21st April 2016

Our Ref: 15-336-ATP Flooding
Letter

ATP Development –Overall Stormwater Flooding Letter

Lower Ground GA Plan

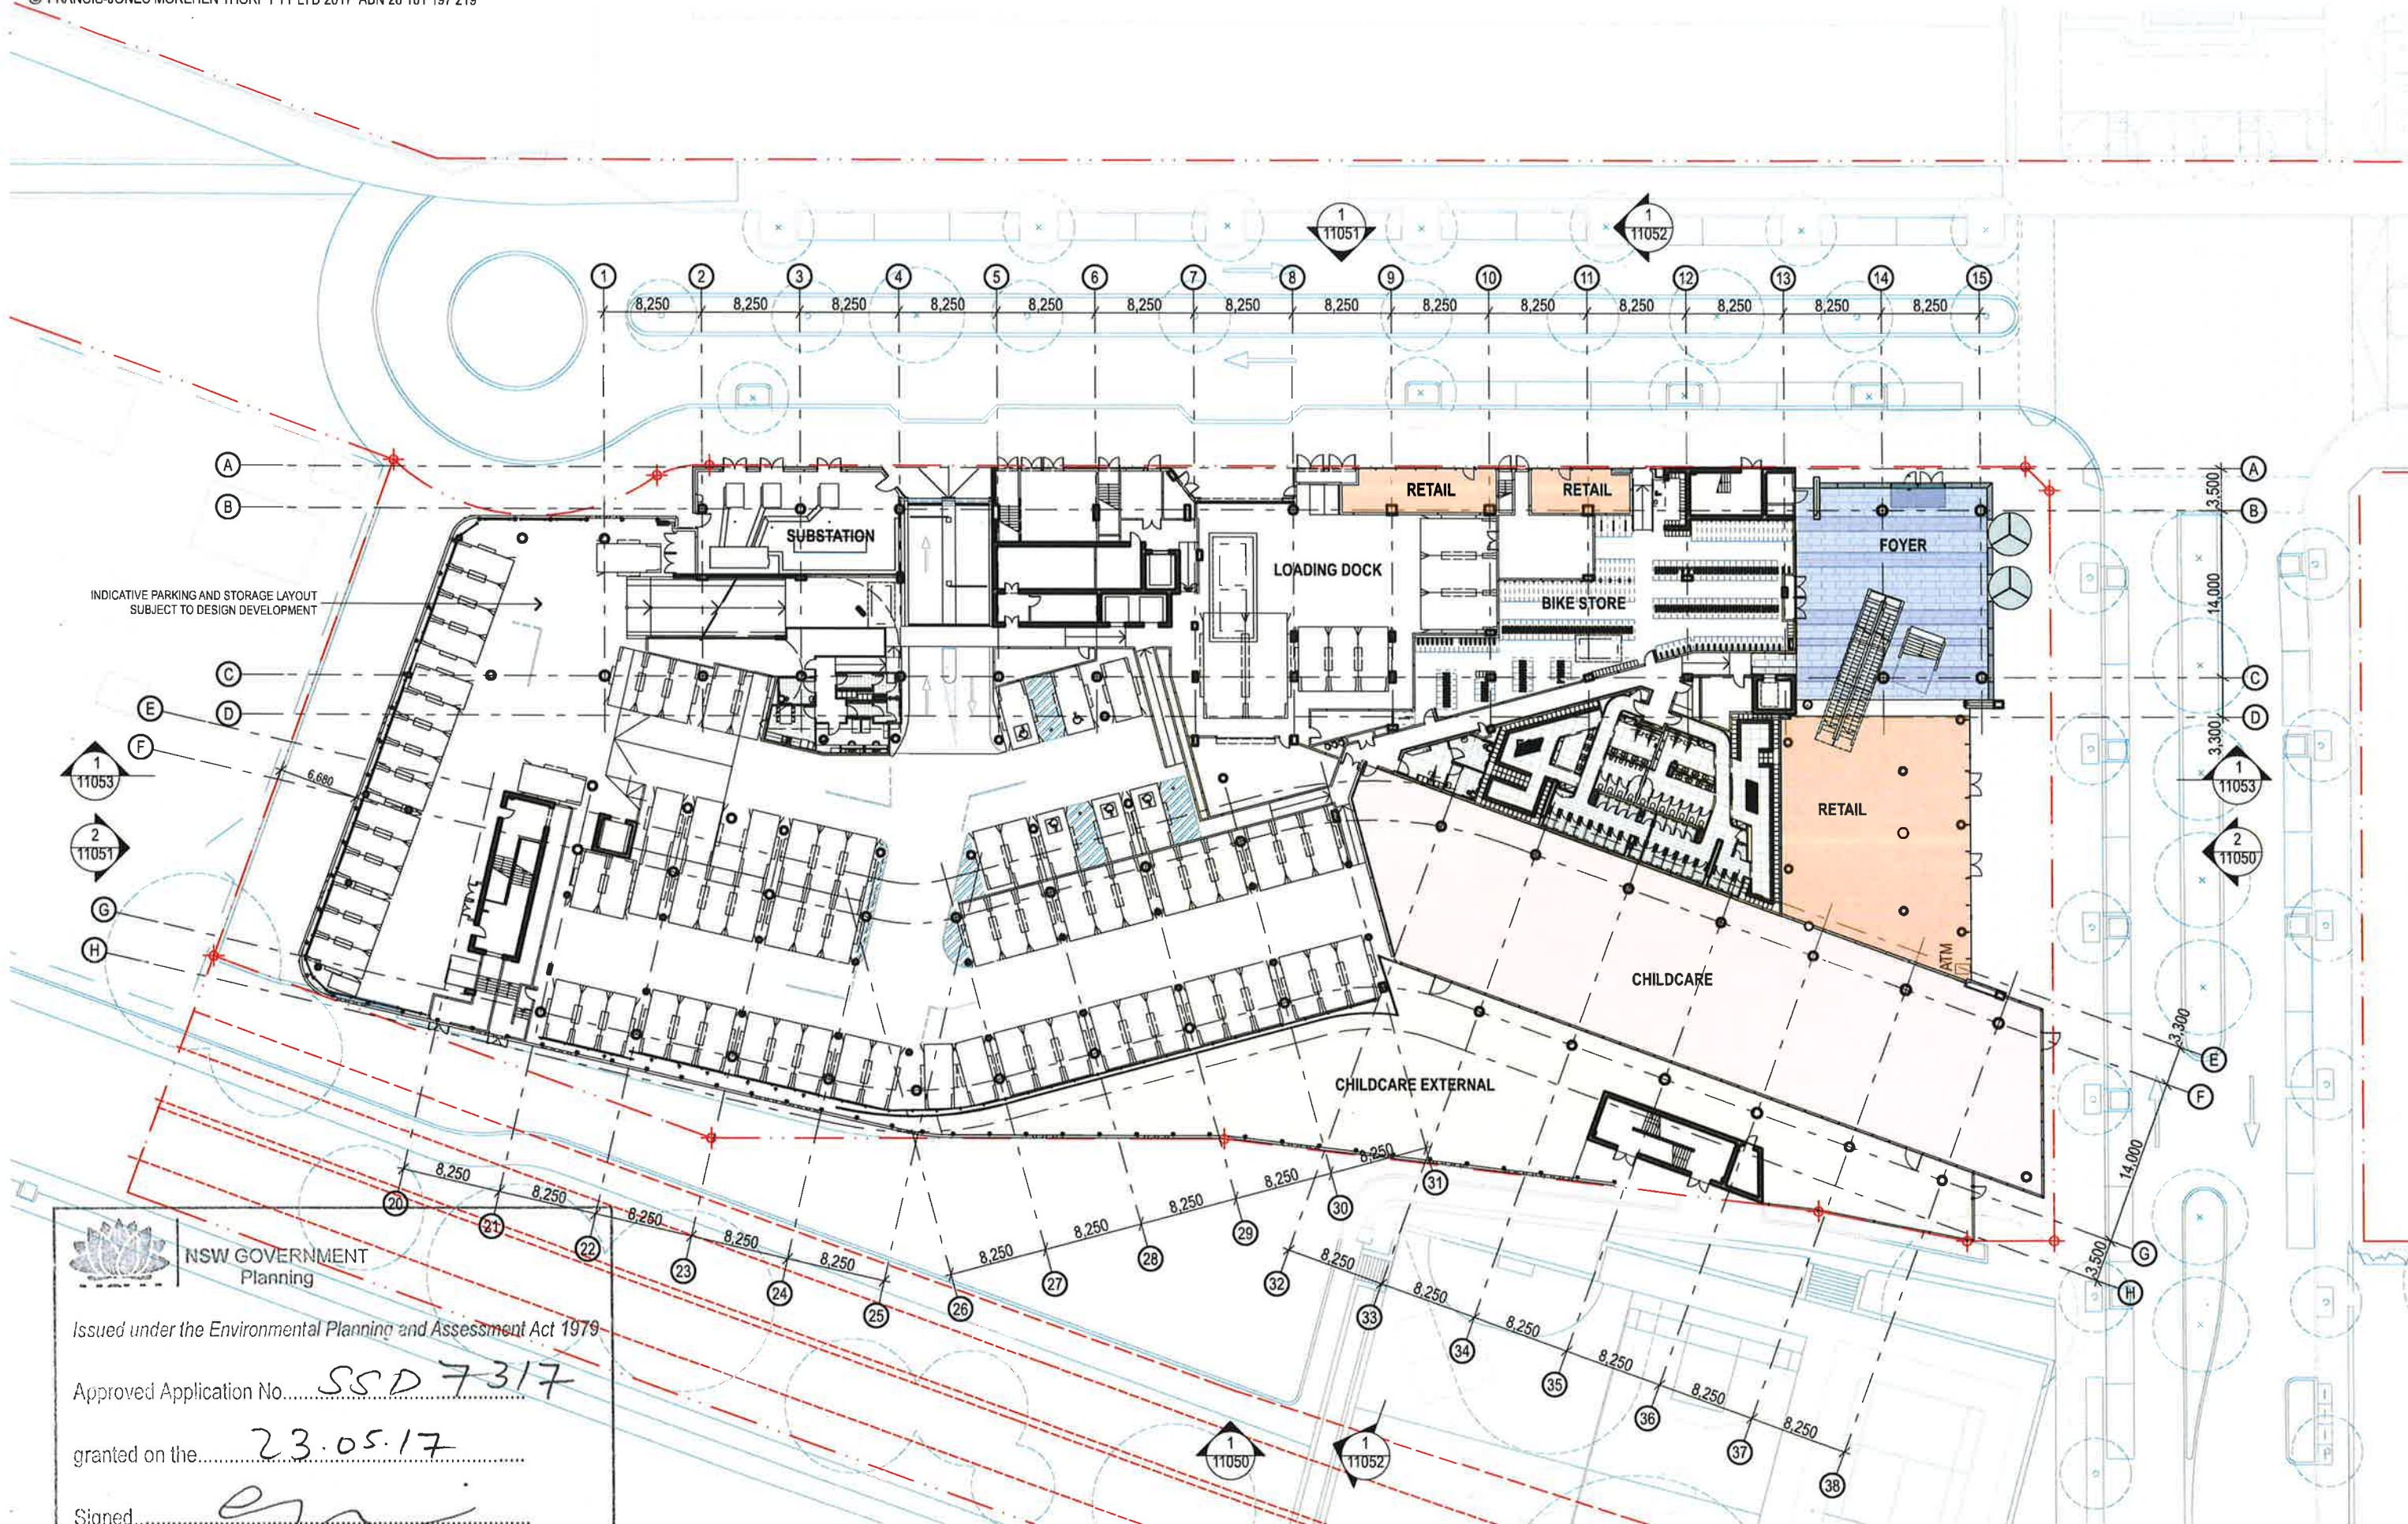
Consideration to be given to the form and mass of Building 1 including relocation of parking to basements.

Given the high level of the known 100yr ARI flood level immediately surrounding Building 1, it is our recommendation as professional civil engineers that there should be no excavation for a basement carpark. It is our recommendation the existing ground level should act as the lower ground level carpark. Introducing a below ground basement carpark beneath Building 1 will increase the risk of overland flows and stormwater surcharging back into the basement. This water would then need to be dealt with via a pump out system.

From a flooding perspective the safest course of action is to maintain the ground levels as they are for carparking and raise the retail and commercial floor levels to suit. This will ensure all ground floor levels are set the minimum freeboard level above the 100 year ARI level to meet Council's flooding guidelines.
